FISHER & PHILLIPS LLP  
ATTORNEYS AT LAW

December 18, 2012

Thomas Dobbins, Chairman  
Portland Harbor Commission  
2 Portland Fish Pier  
Marine Trade Center, Suite 105  
Portland, Maine 04101

Re: New Yard LLC, Proposed New Facility, Portland Harbor, Maine

PROJECT: CANAL LANDING  
 SHEET TITLE: SITE DEVELOPMENT PLAN PHASE 1A (SUMMER/FALL 2013) AND 1B (DATE UNDETERMINED)  
 CLIENT: NEW YARD LLC  
 58 FORE STREET  
 PORTLAND, ME 04101

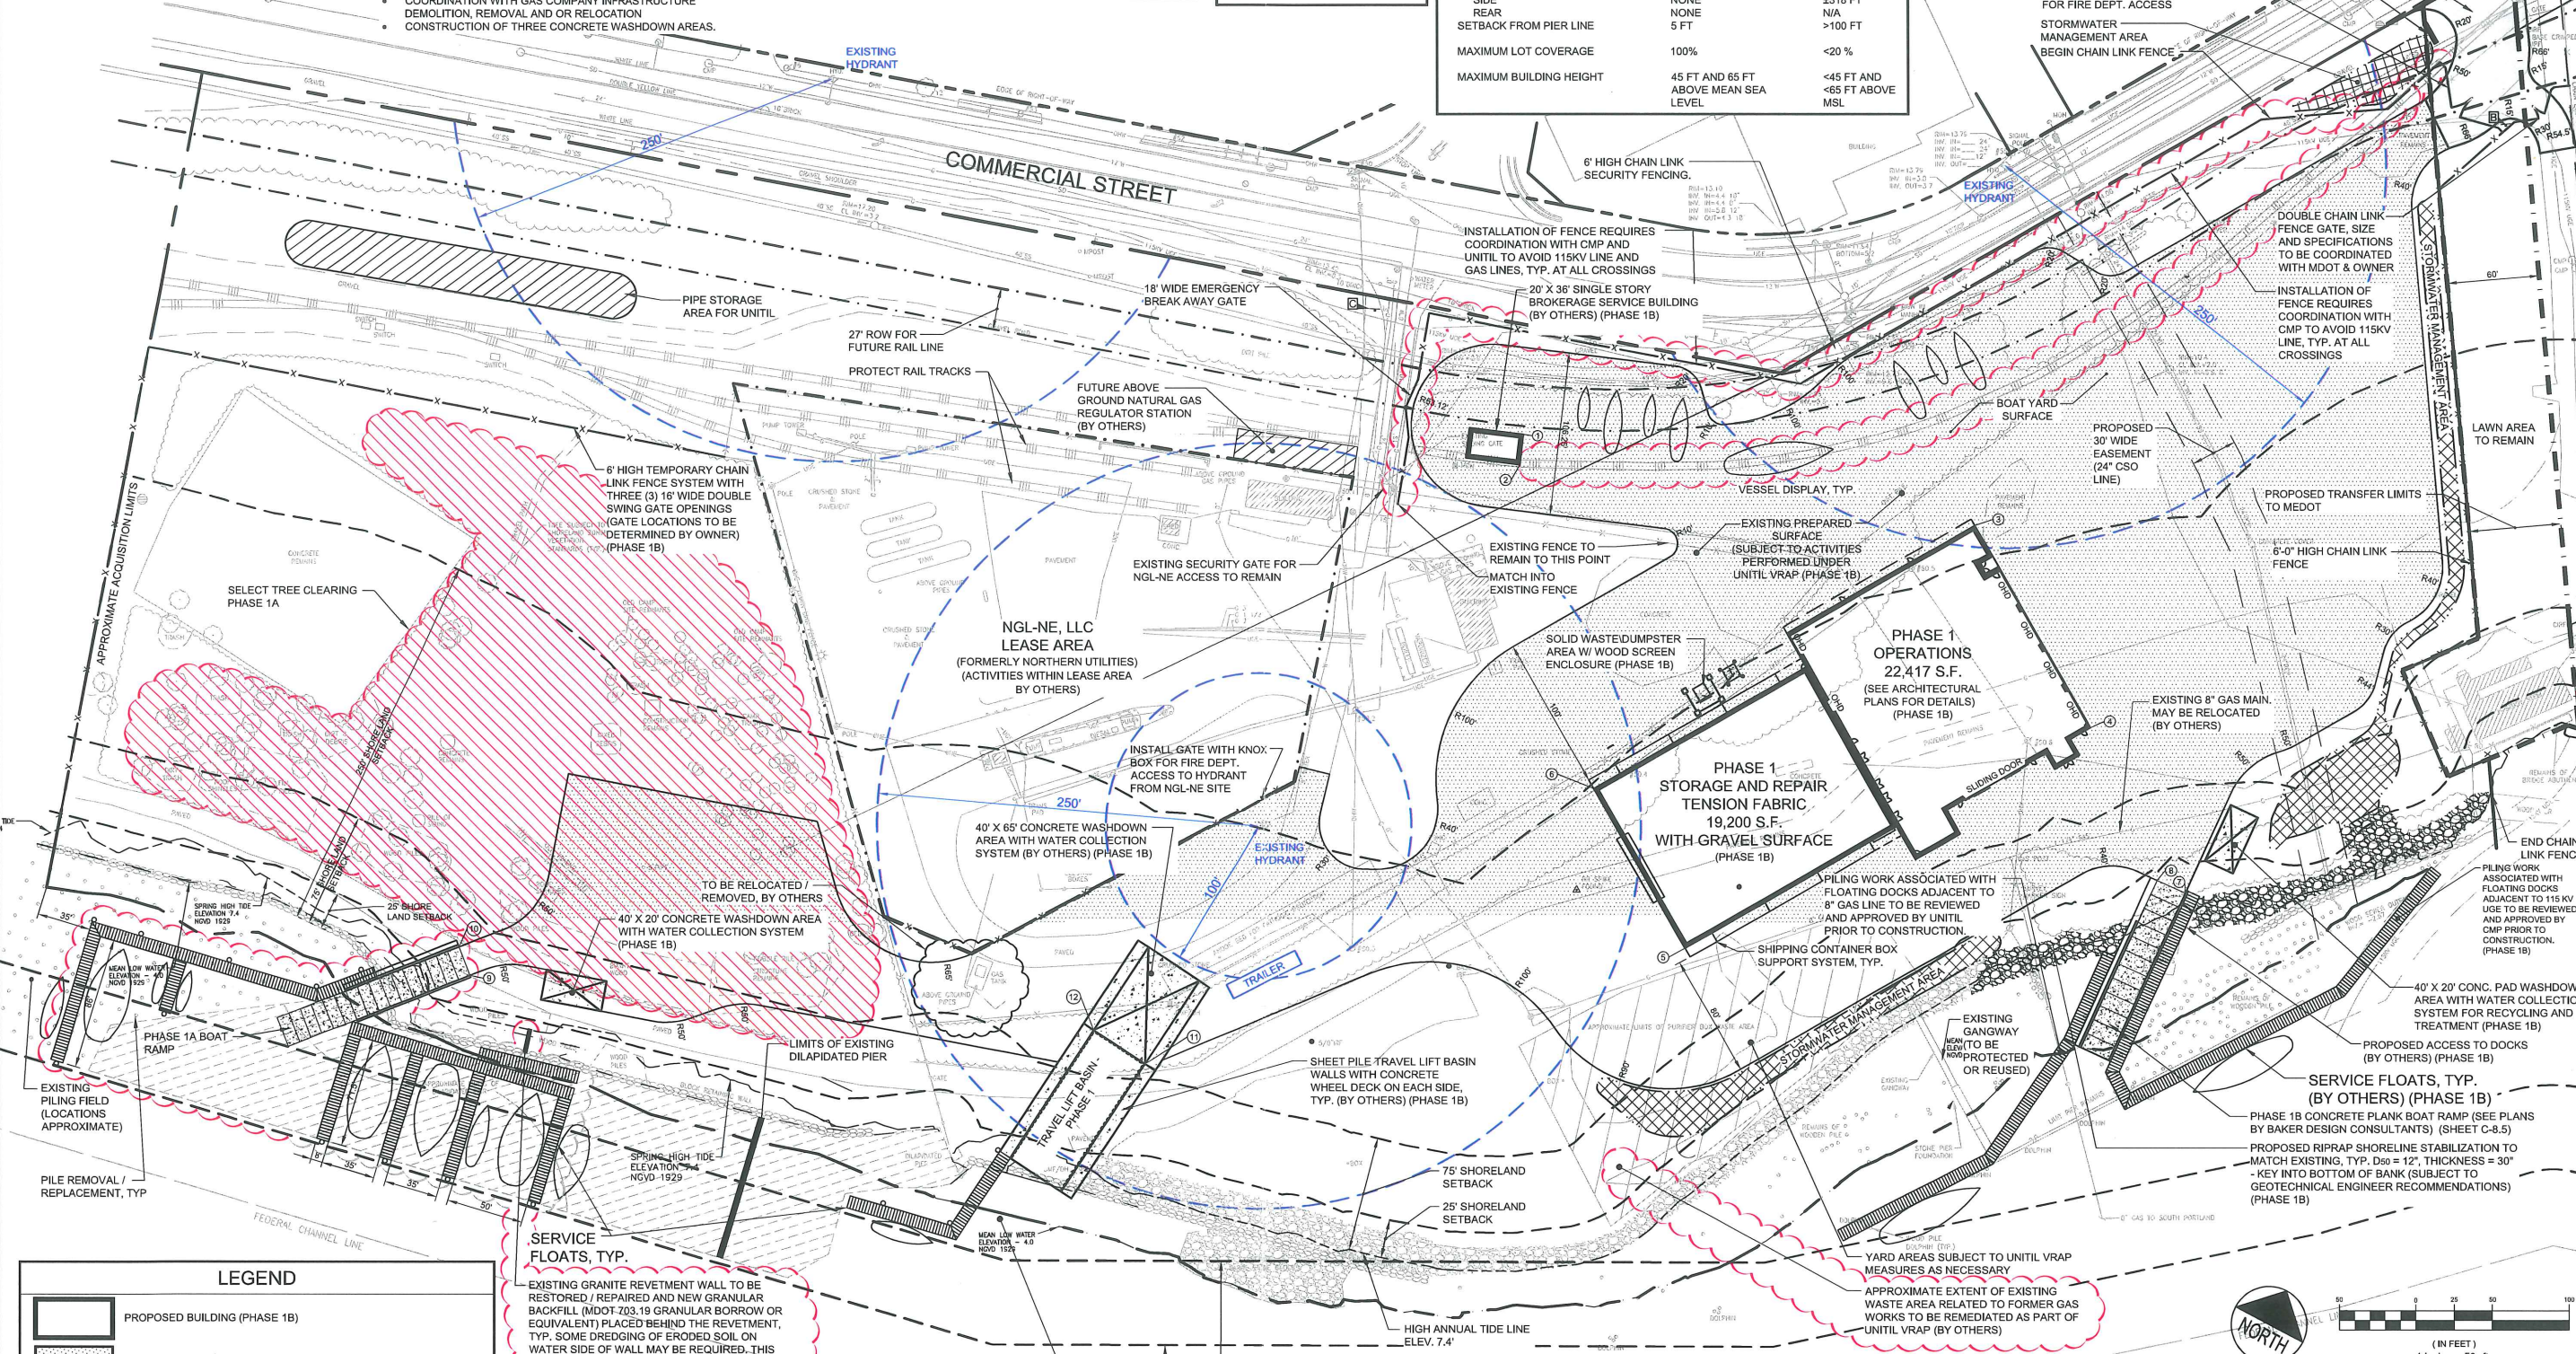
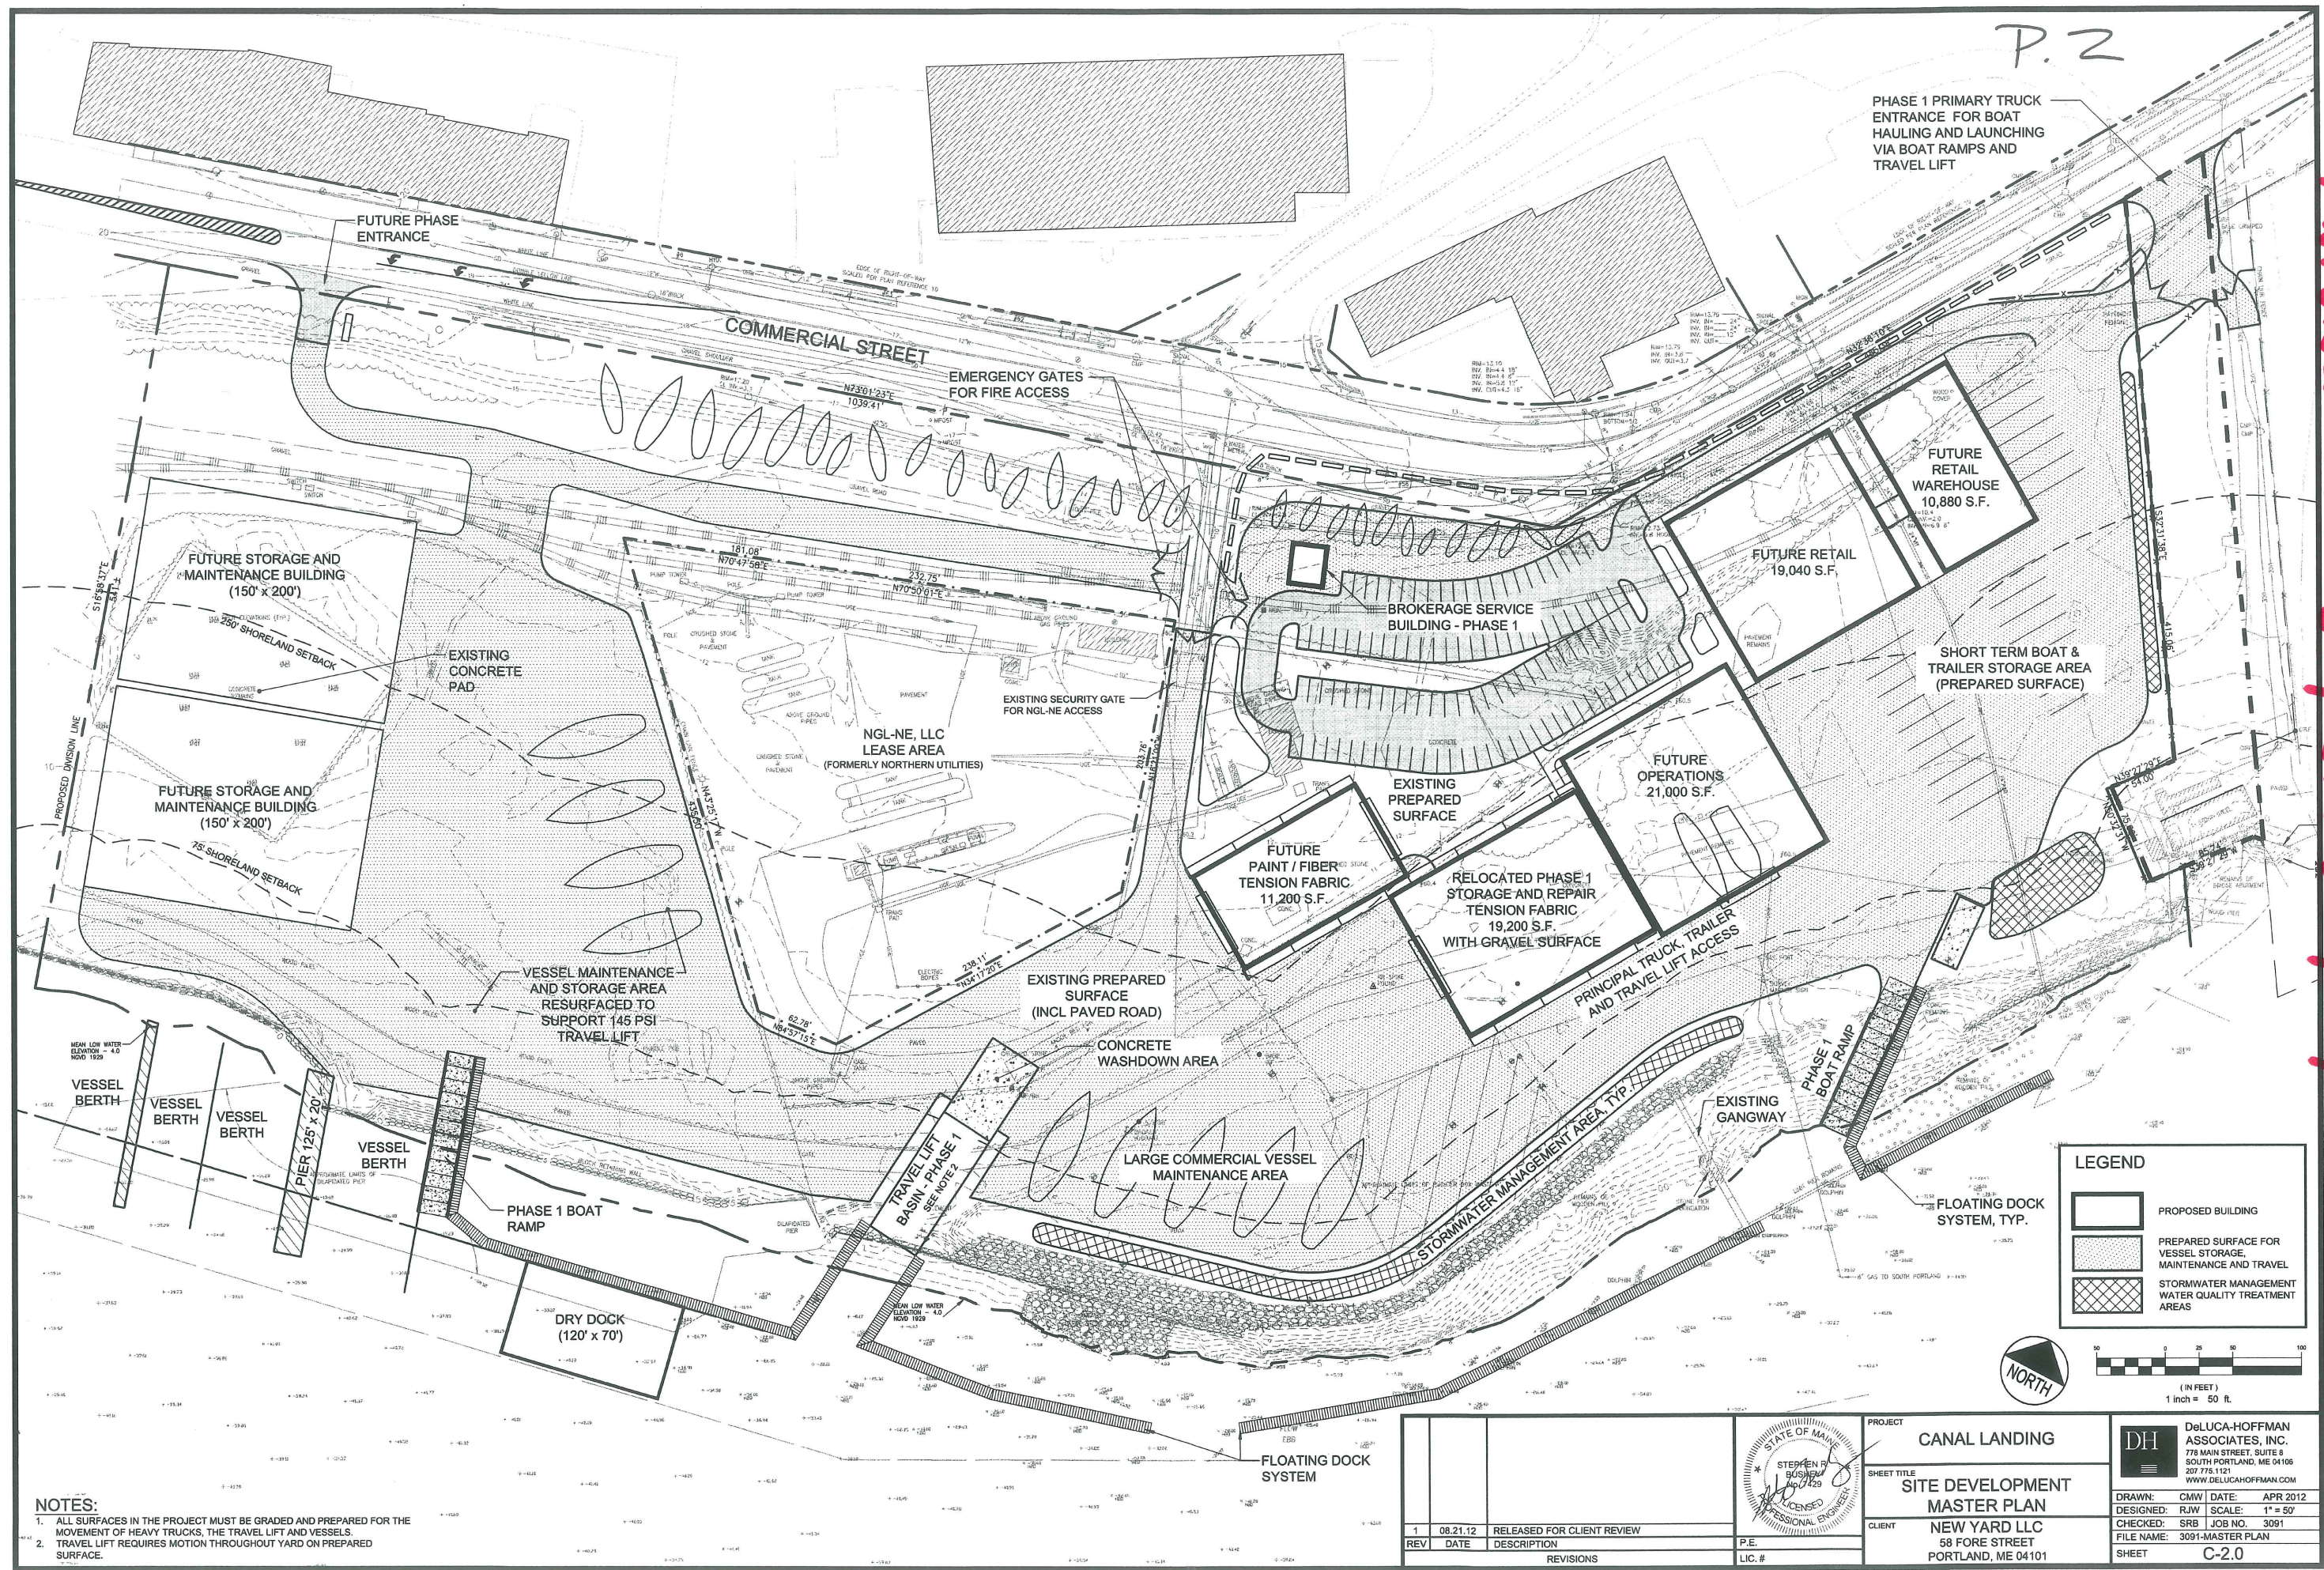
In reviewing the plans for the floating docks at the Proposed Facility, it is clear that although the docks themselves may be just inside the Harbor Commissioners' line, any vessel berthed alongside the docks would be outside the lines and, thus, in the channel.

New Yard LLC's Proposed Facility, at least as it pertains to the number and location of the floating docks and dry-dock, creates a danger to the safety and commerce of Portland Harbor. As noted on the Commission's own website, "The Board's primary responsibilities are to ensure navigational safety within the harbor." It is hard to believe that the Commission could find that the proposed floating docks and dry-dock would not "substantially or unreasonably interfere with navigation or injure rights of others." See Maine Private and Special Laws 1981, chapter 98, Section 5, the enabling legislation creating the Commission.
